January 29, 2024

Reference: Engineering Services  
504 CC Byrd Ln.  
Linden, NC 28356  
TE&D Project No.: 2401-020053

1. Analysis of the existing basement foundation walls for proposed construction.

SHEET NAME:  
(EXISTING) FOUNDATION PLAN

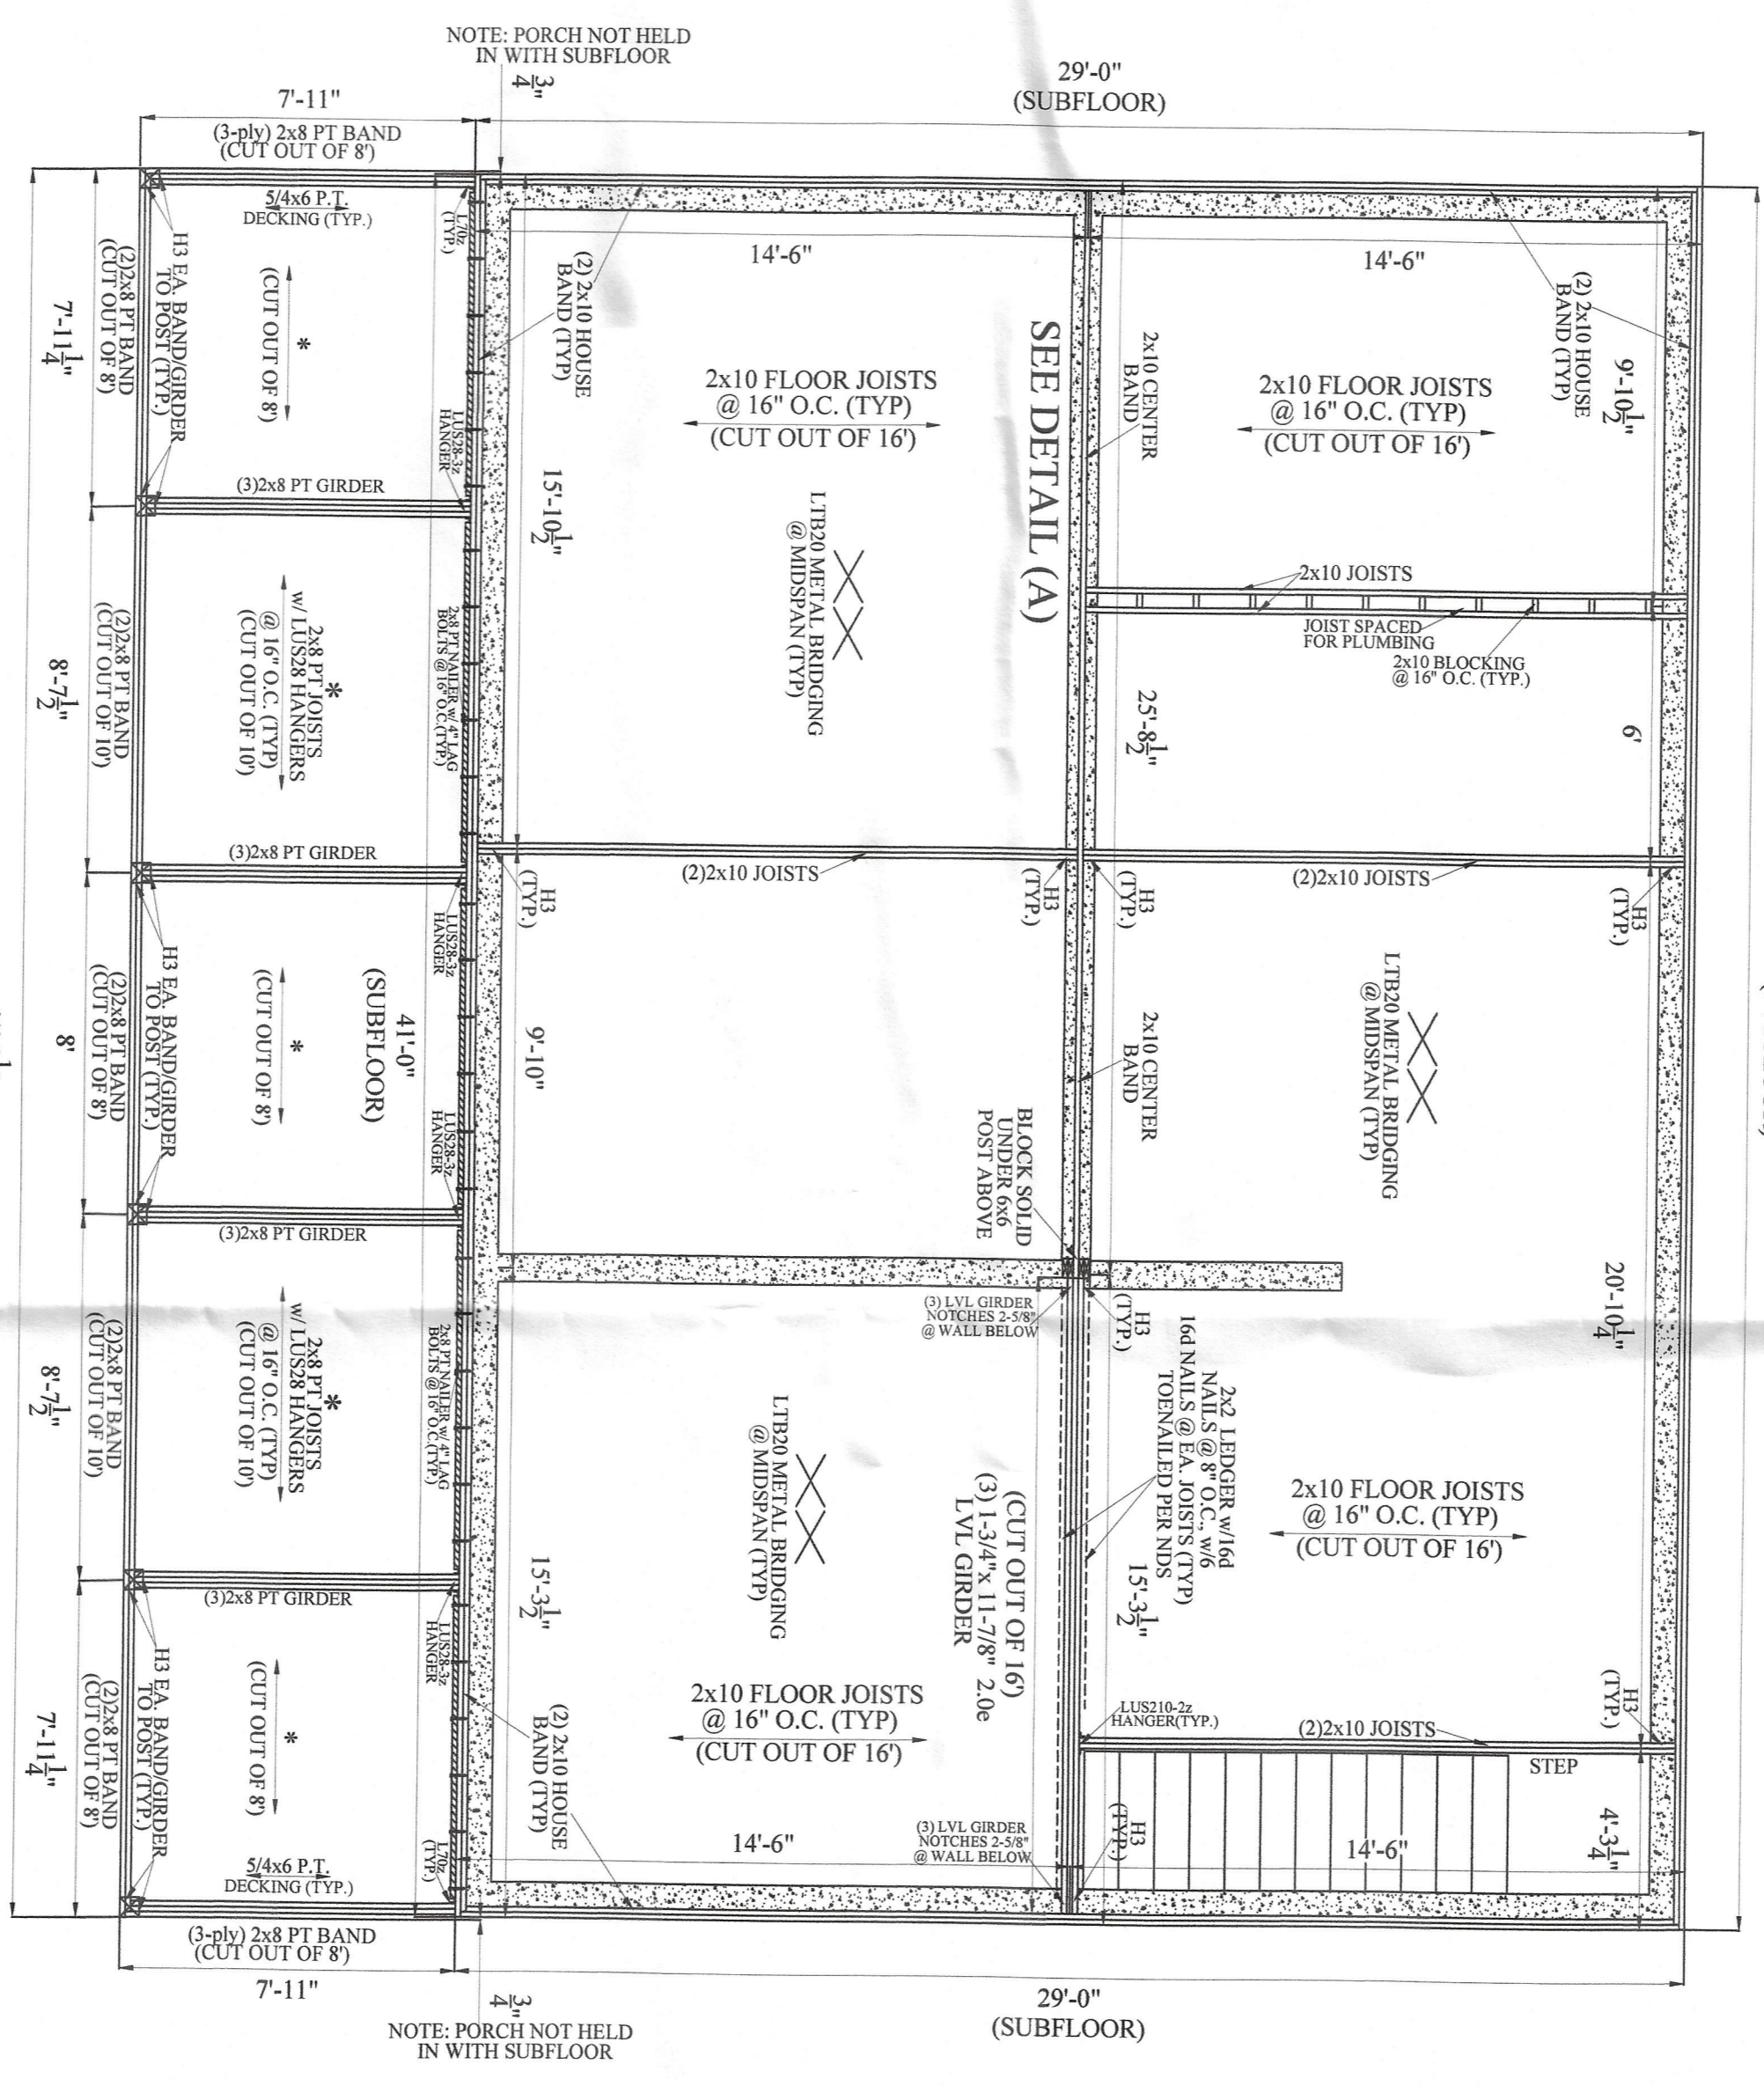
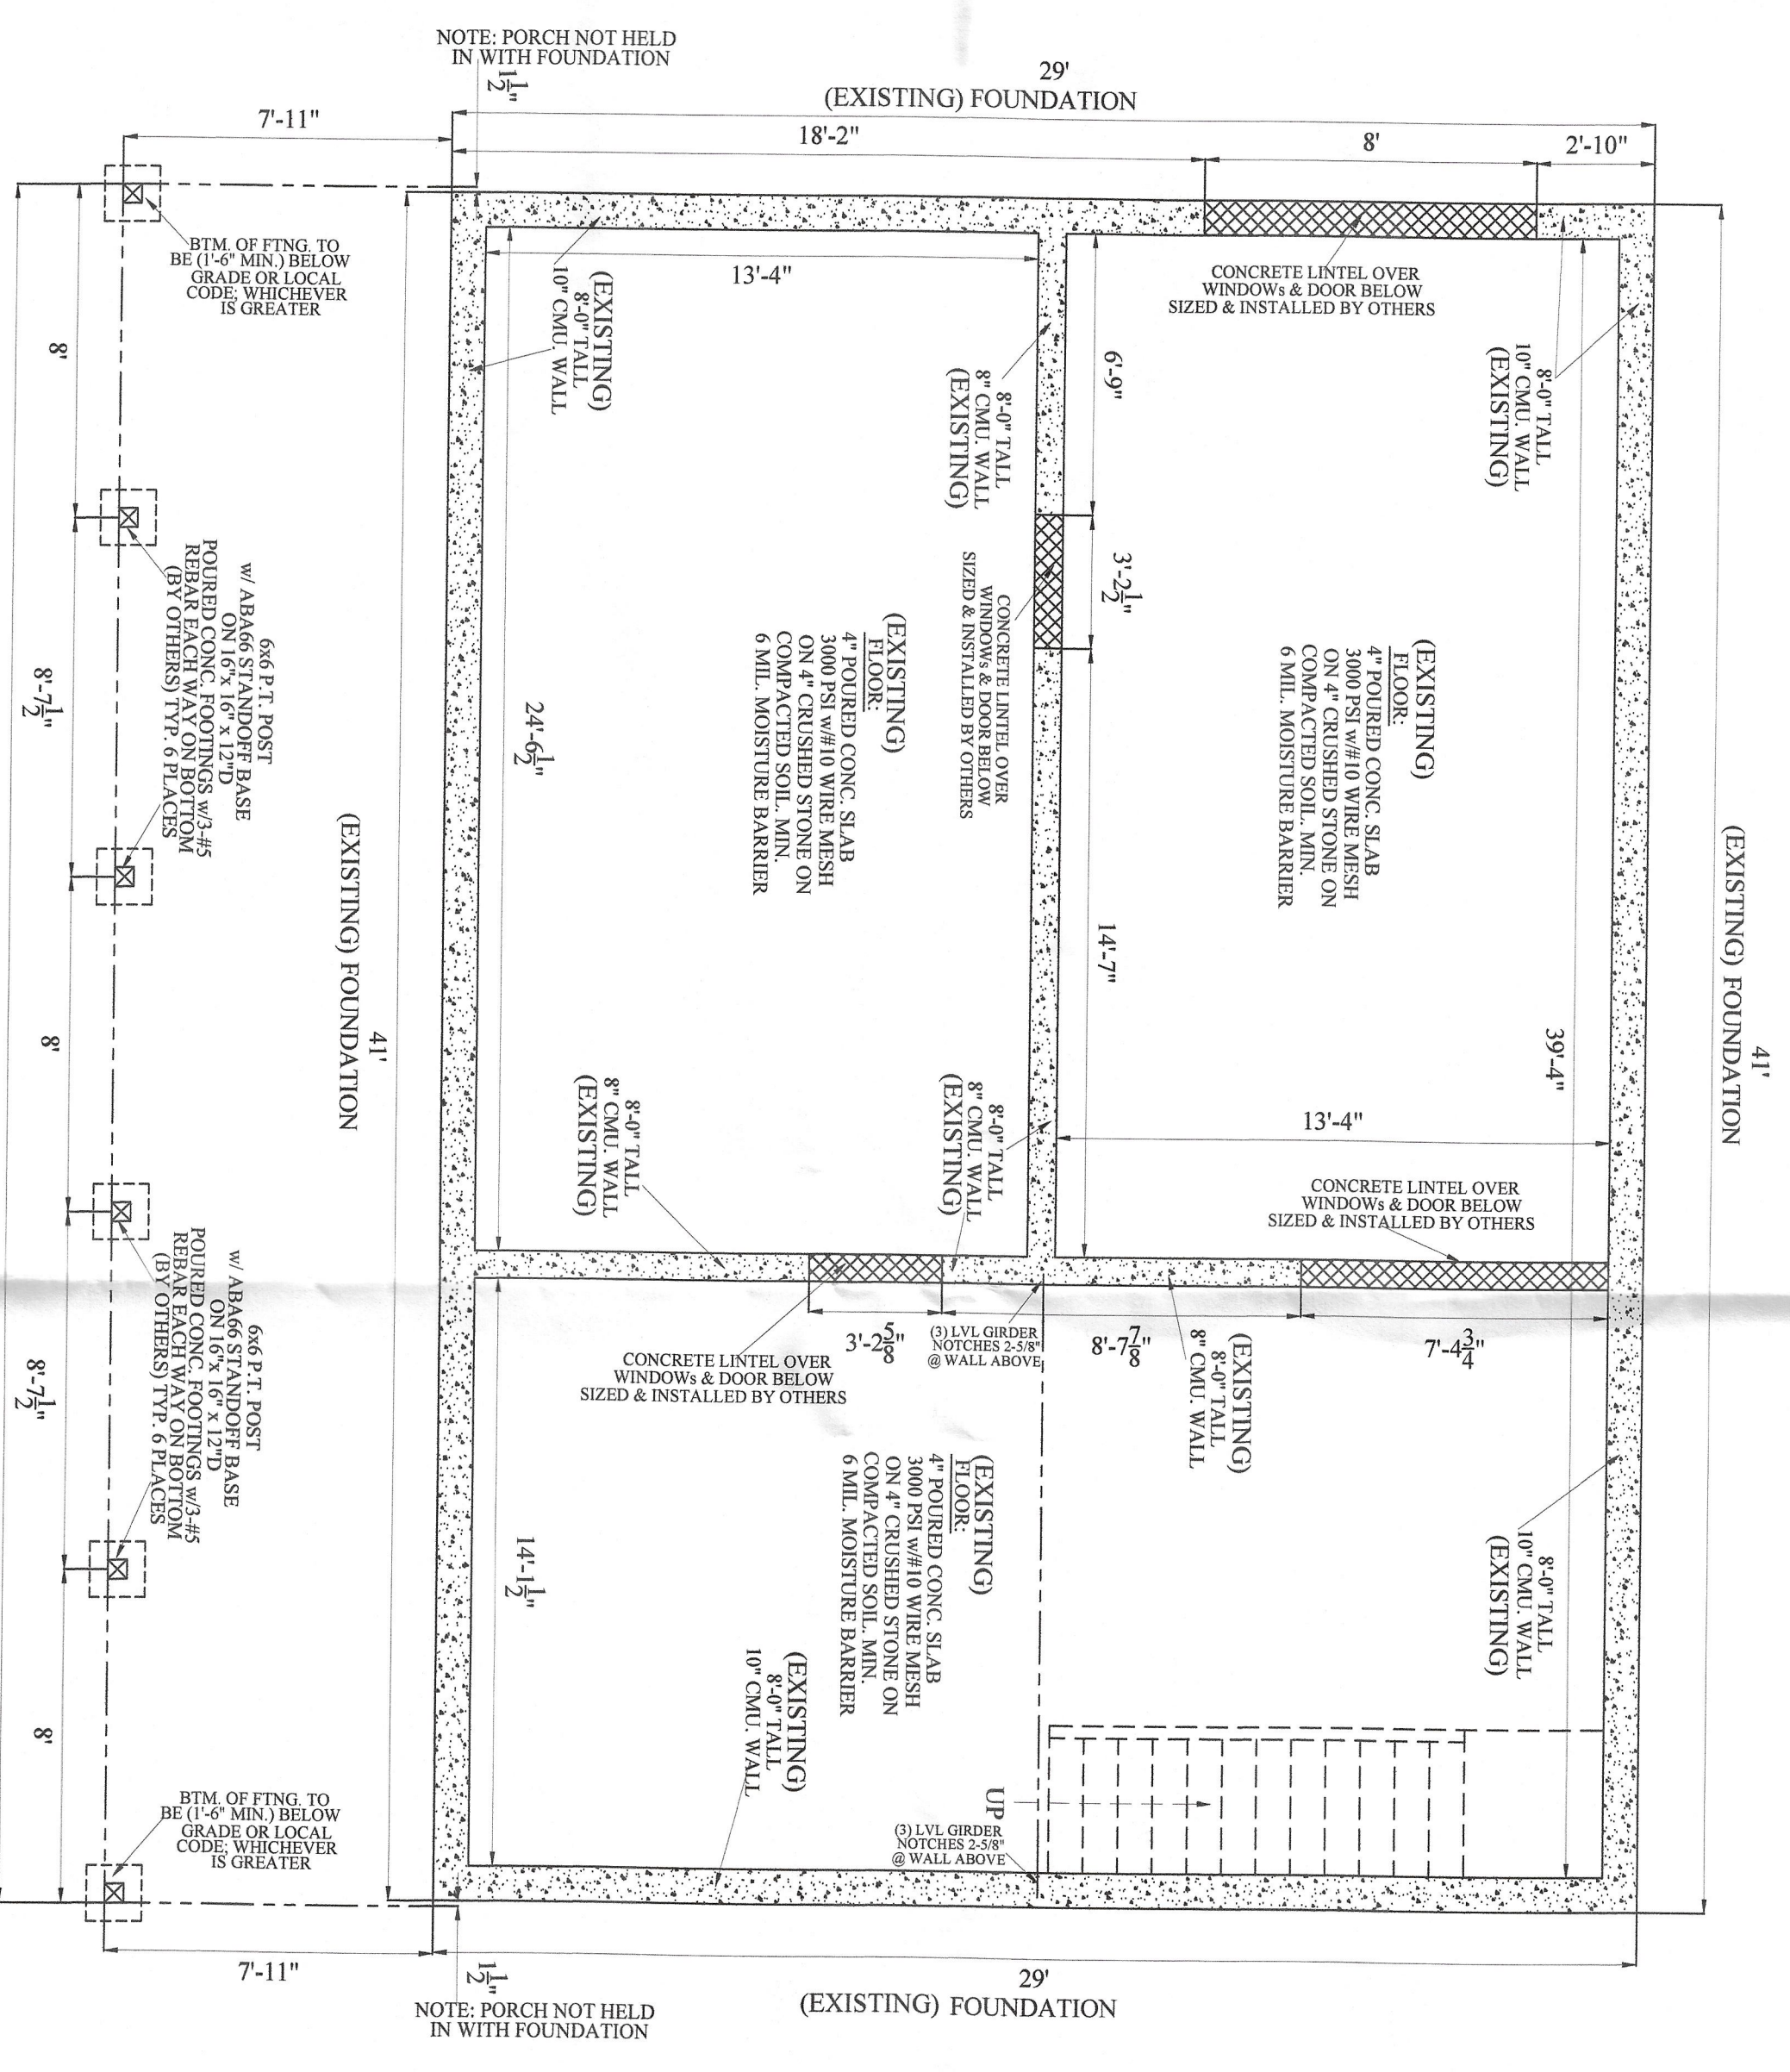
1. We observed an 8'-0" tall CMU basement foundation comprised of 10" wide CMU blocks at the exterior walls and 8" wide CMU blocks at the interior walls. The foundation wall was installed on an 18" wide by 8" deep continuous concrete footing. The exterior foundation was reinforced with #4 rebar installed vertically at 48" o.c. and with horizontal "H-wire" installed at 16" o.c. Based on our observations and analysis, the following modifications and repairs are to be installed:

- A. Impact damage was observed at the right exterior foundation wall. All damaged CMU blocks are to be removed and the damaged section of the foundation wall is to be rebuilt per the 2018 North Carolina Residential Building Code by a certified mason.

- B. Impact damage was observed at the back-exterior foundation wall. All damaged CMU blocks are to be removed and the damaged section of the foundation wall is to be rebuilt per the 2018 North Carolina Residential Building Code by a certified mason.

- C. Multiple vertical #4 rebar was missing from the back-exterior wall of the foundation. New vertical #4 rebar reinforcement is to be installed at 48" o.c. in the back wall per the 2018 North Carolina Residential Building Code.

- D. Not all cells housing the vertical rebar reinforcement were filled solid with concrete. Due to the lack of concrete cover, the rebar reinforcement has been exposed to inclement weather since initial construction and may have started to corrode. TE&D recommends installing a new vertical #4 rebar reinforcement in the cell beside the rebar exposed to inclement weather. The new rebar is to be installed per the 2018 North Carolina Residential Building Code. All rebar cells are to be filled solid.

- E. The top course of CMU on the foundation walls is to be fully grouted per the 2018 North Carolina Residential Building Code.

Note: TE&D recommends cleaning the interior of all CMU cells with compressed air to remove dust and debris before installing the repairs above.
